Reviewed for Code Compliance
Inspections Division
Approved with Conditions
Date: 05/03/18

Building Permit #2017-01190, 89 Pleasant Ave., PI

Please provide the remaining items:

FIRST FLOOR

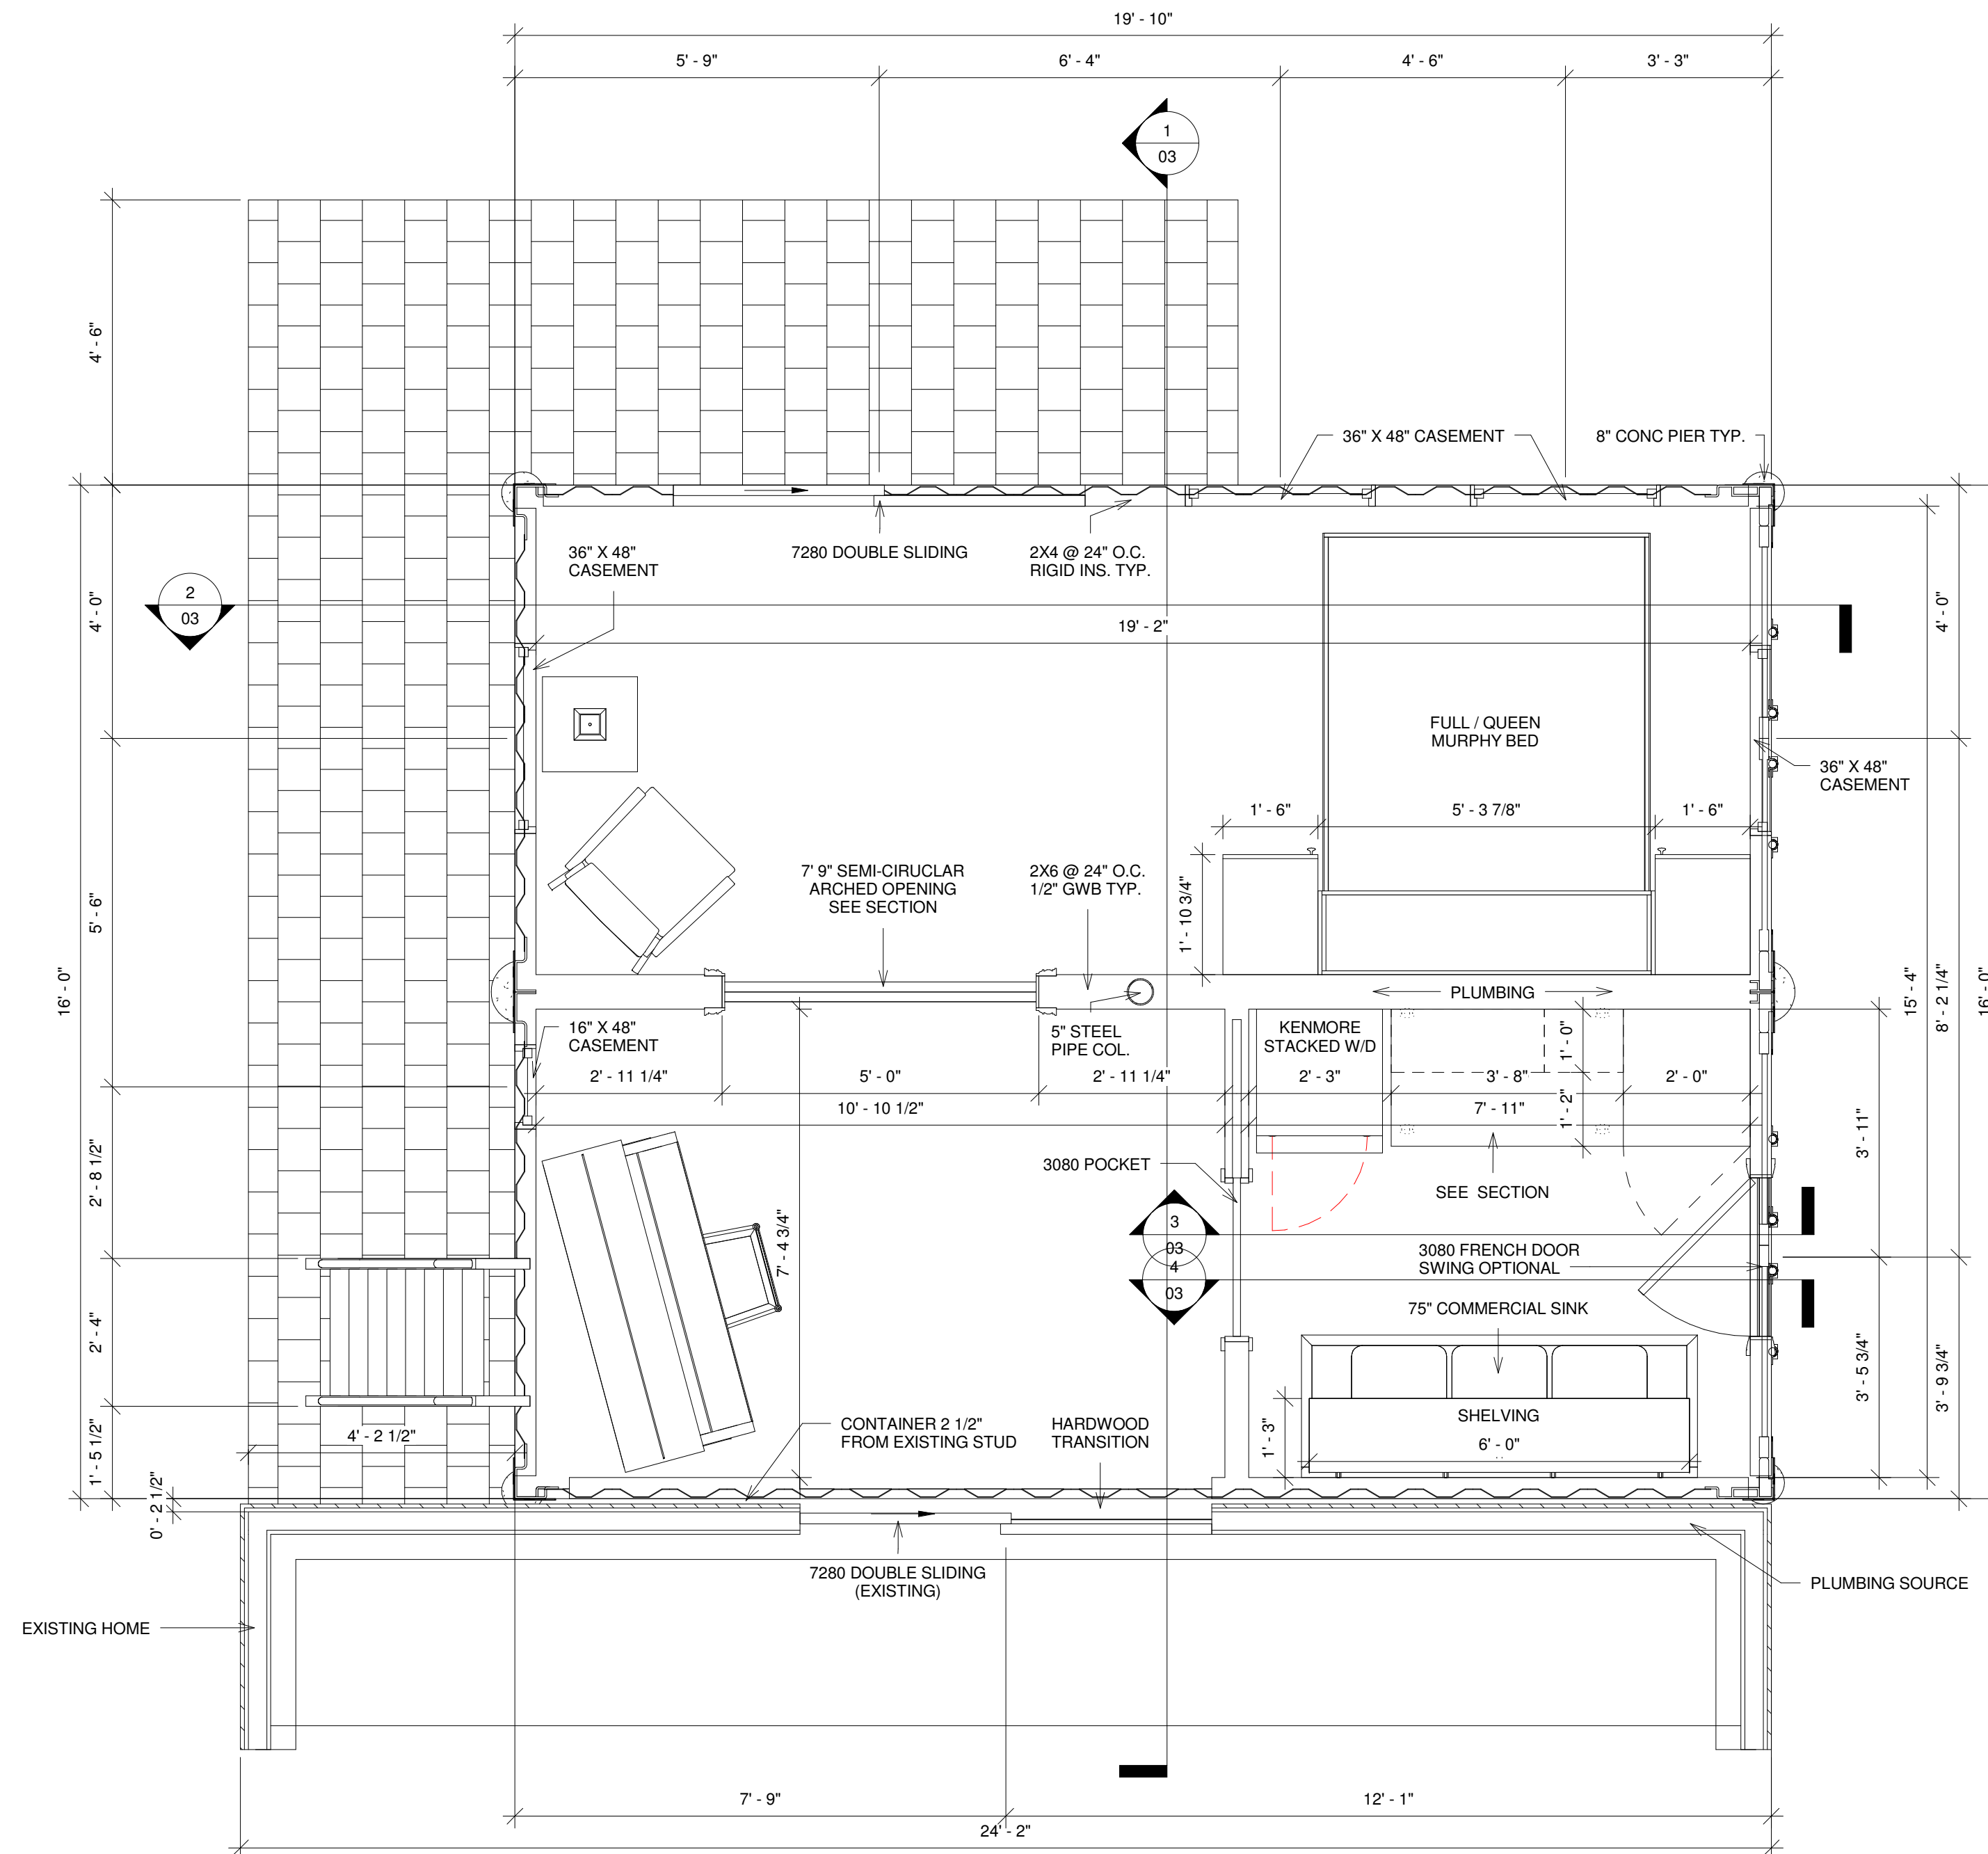
1. Structural plans for the modified shipping container.
2. Structure anchoring specifications and details.
3. Footing & pier dimensions, depth, and reinforcement.
4. Insulation R-factor levels for floor, walls and ceiling.
5. Window and door schedule including U-factor levels.
6. Smoke and carbon monoxide locations.
7. Construction of any new exterior landing, steps and railings based on the height off grade.
